TWEED VALLEY HOSPITAL – 771 CUDGEN ROAD

OCTIEF have been requested to provide a response to the letter from Dr Allison Adams regarding a former cattle dip and arsenic contamination at the site at 771 Cudgen Road, Cudgen, and the comments and recommendations in the associated e-mail dated 24 January 2019 from Christina Low of the NSW Environment Protection Agency. The letter primarily relates to anecdotal evidence from Mr Brent Gibson, outlining the potential for a former cattle dip in the general area of the recently demolished site shed.

Figure 6 : Farm pit and shed
GW/SW sample locations **19038 R02**

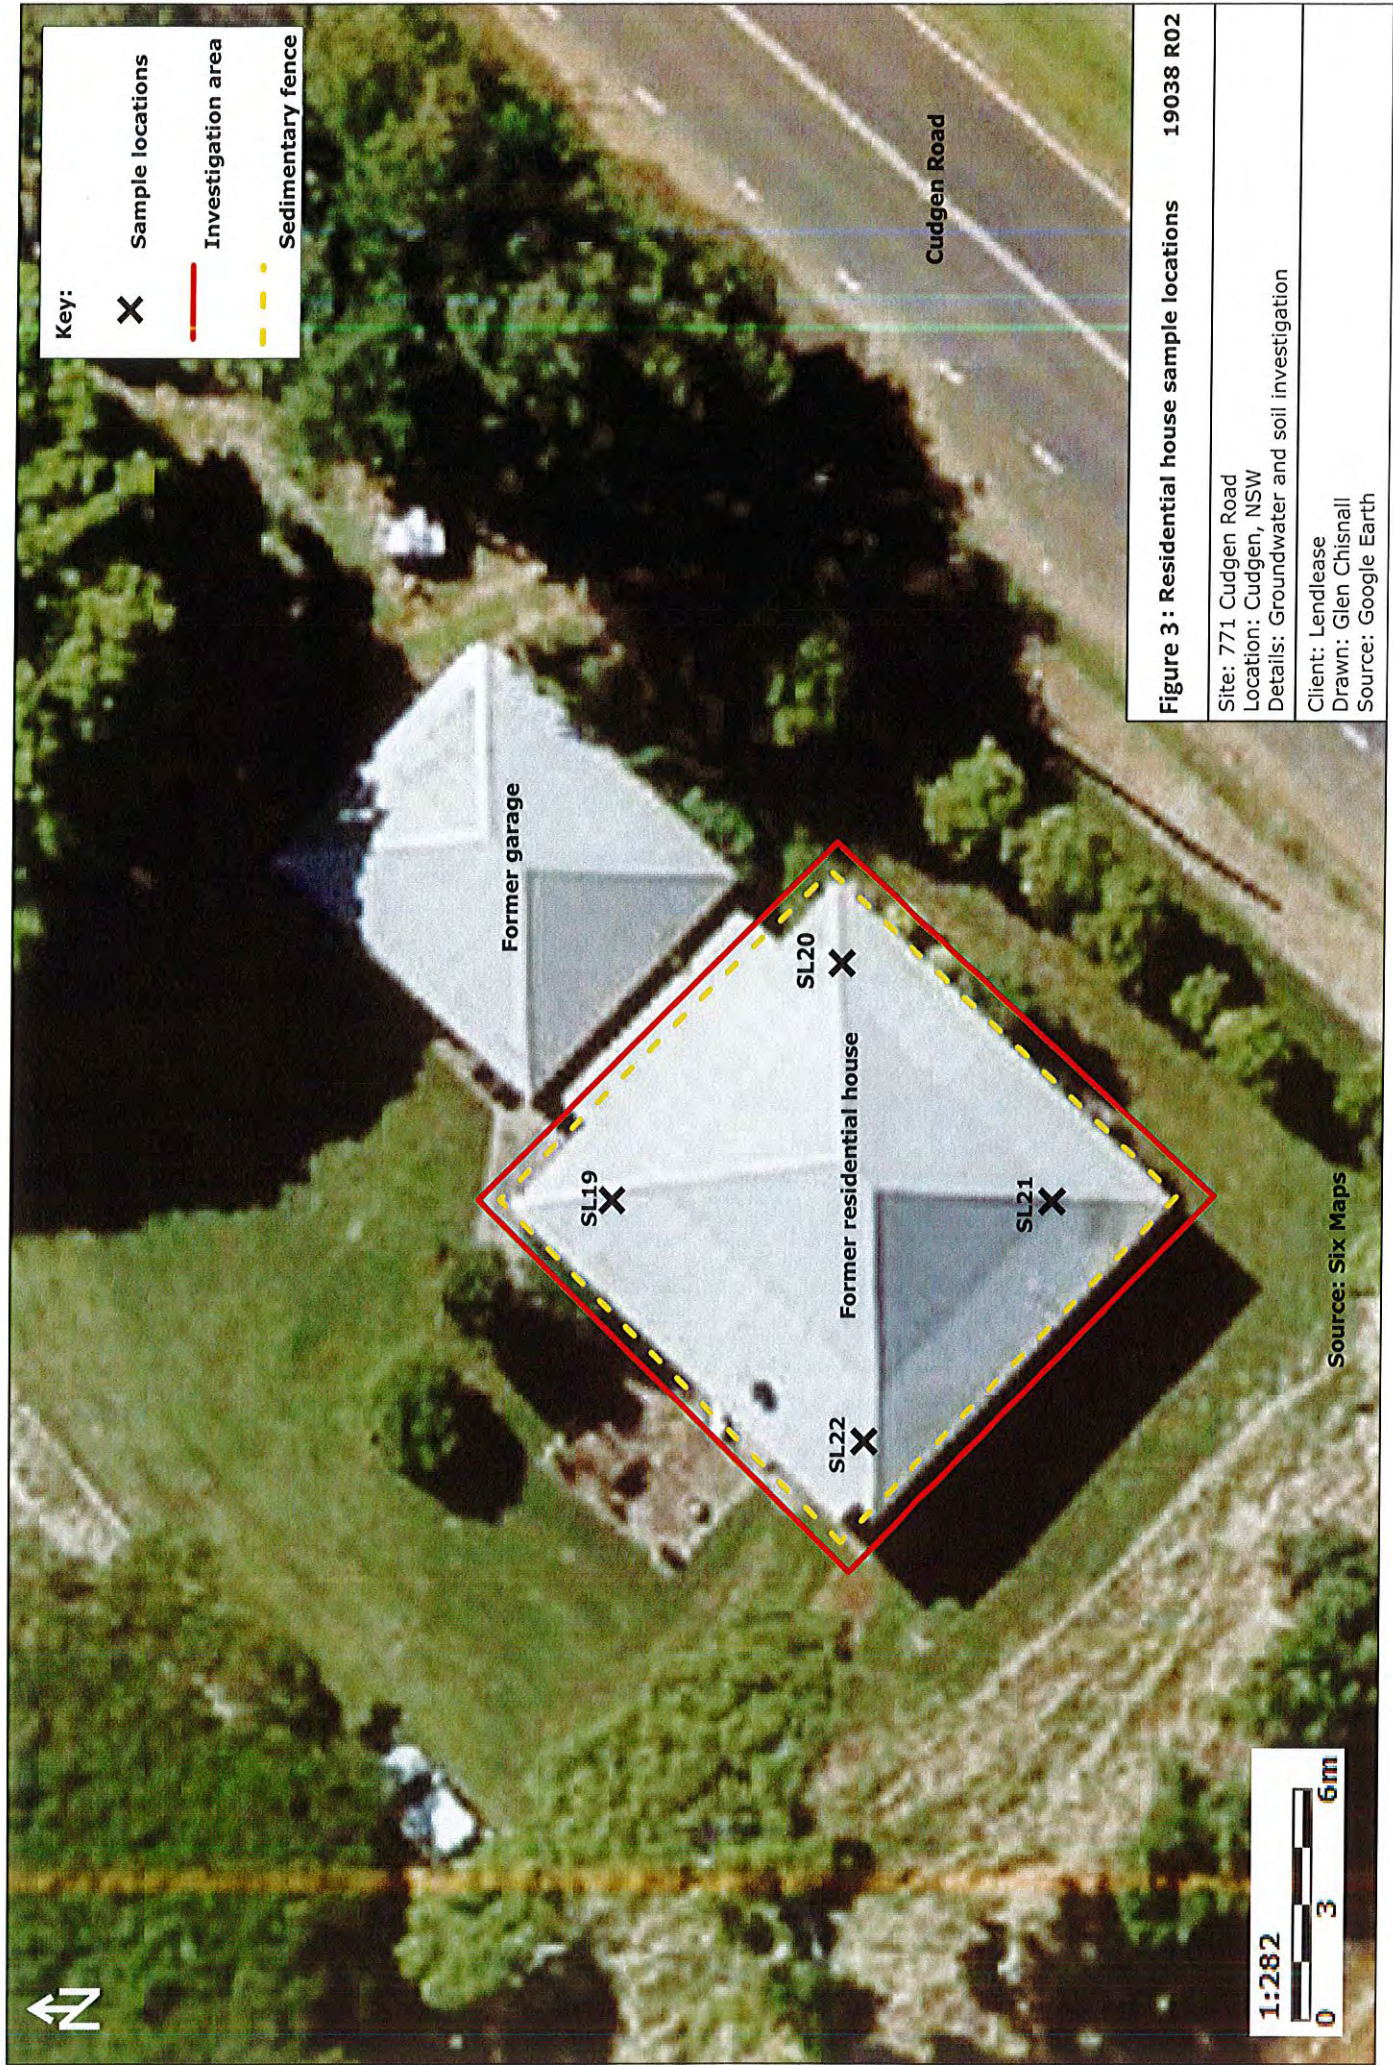
- i) **“The report found higher than normal arsenic levels in the vicinity of the shed area of the site that were at least double that of all other samples tested however only a few samples were tested and the shed area was not investigated further in any great detail. It is therefore highly likely that this area in and around the shed has been overlooked as a contamination hotspot, and poses a real threat to the health and safety of workers on site..... The Main Shed and the Vehicle Shed had 3-4 times higher arsenic levels at 21 and 24 mg/kg respectively”. And that “These findings support Mr Gibson’s recount from his father of there being a cattle dip on site.”**

The concentrations of arsenic in the soil samples reported near the shed location were found to be elevated above what was been reported for the other samples collected from across the development area. However, the EPA agrees with Octief that all arsenic soil results reported were below appropriate health risk screening criteria. Nonetheless, it appears that the assessment did not identify the likelihood of cattle tick dip activities the redevelopment area, and it did not design the sampling program to consider this. Further data gap investigations involving targeted soil sampling should be conducted to confirm presence or absence of cattle tick dip infrastructure and contamination on this site. (Response also relates to recommendations 2 and 3).

Further investigation works to address the anecdotal information regarding the potential cattle dip in the vicinity of the shed are outlined in the revised Remediation Action Plan. Due to the absence of any documentation regarding the location of the potential dip, testpitting across the identified area following

Following consultation with the site auditor, a data gap investigation to address the anecdotal information regarding the potential for a cattle dip on the site has been included in a revision of the Remediation Action Plan (RAP) for the site. Due to the absence of any documentation regarding the location of the potential dip, testpitting across the identified area following the removal of surface infrastructure and concrete slabs is required to enable characterisation of the area.

Figure 7 : Farm dump and dam
GW/SW sample locations **19038 R02**

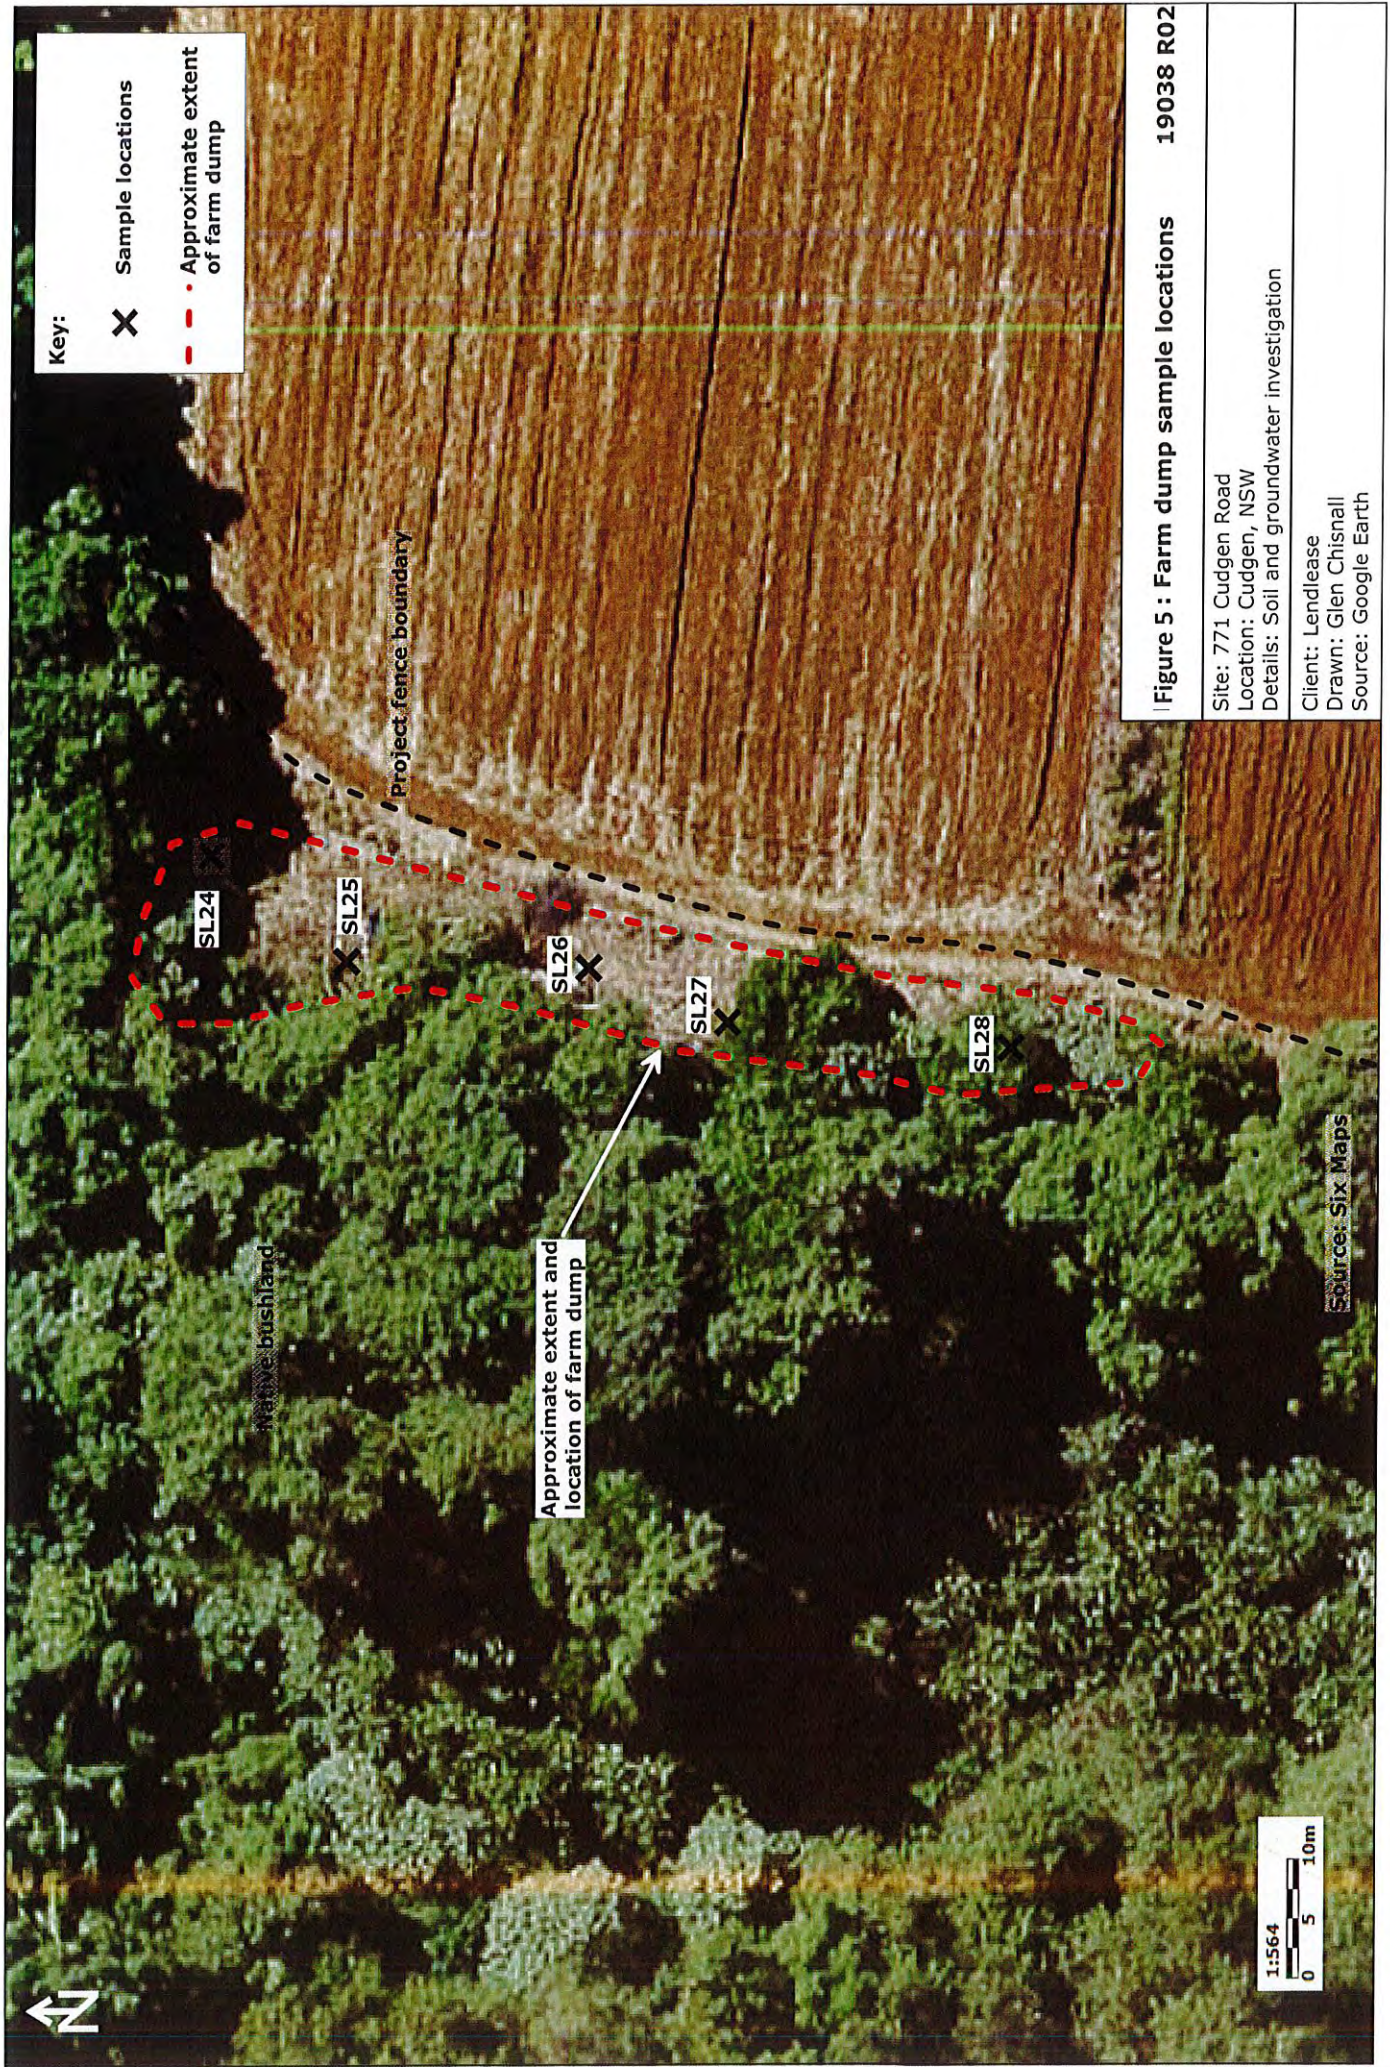
- ii) **“In addition, the dump area of the site also contains elevated levels of arsenic compared to the paddock areas with levels of 8.6 mg/kg. This area has also not been tested in full due to vegetation impeding access as stated in the Octief report (p. vi). It is plausible that previous users of the site may have disposed of highly toxic chemicals such as arsenic in the area and then avoided maintaining the area for this reason, hence the overgrowth”.**

- c) A small farm dump was reported to be located on the edge of a vegetated area in the northwest corner of the site. A visual inspection of the dump identified only inert building materials such as fencing posts, and paving bricks, however due to extensive coverage by vegetation the full extent of the dump could not be clearly determined. Furthermore, farm dams on site were reported as having restricted access and as such have not been fully investigated for contamination. The EPA considers therefore that there are several locations on this site that should be further investigated for contamination. (also relates in part to recommendation 1)**

While some areas of the farm dump were not accessible, two targeted soil sampling locations were completed within the area of the dump during the detailed site investigation. These locations reported no elevated concentrations of potential contaminants, and given the size of the farm dump, two targeted samples are considered adequate to characterise the soil in this area.

As outlined above, while some areas of the farm dump were not accessible, two targeted soil sampling locations were completed within the area of the dump during the detailed site investigation. These locations reported no elevated concentrations of potential contaminants, and given the size of the farm dump, two targeted samples are considered adequate to characterise the soil in this area.
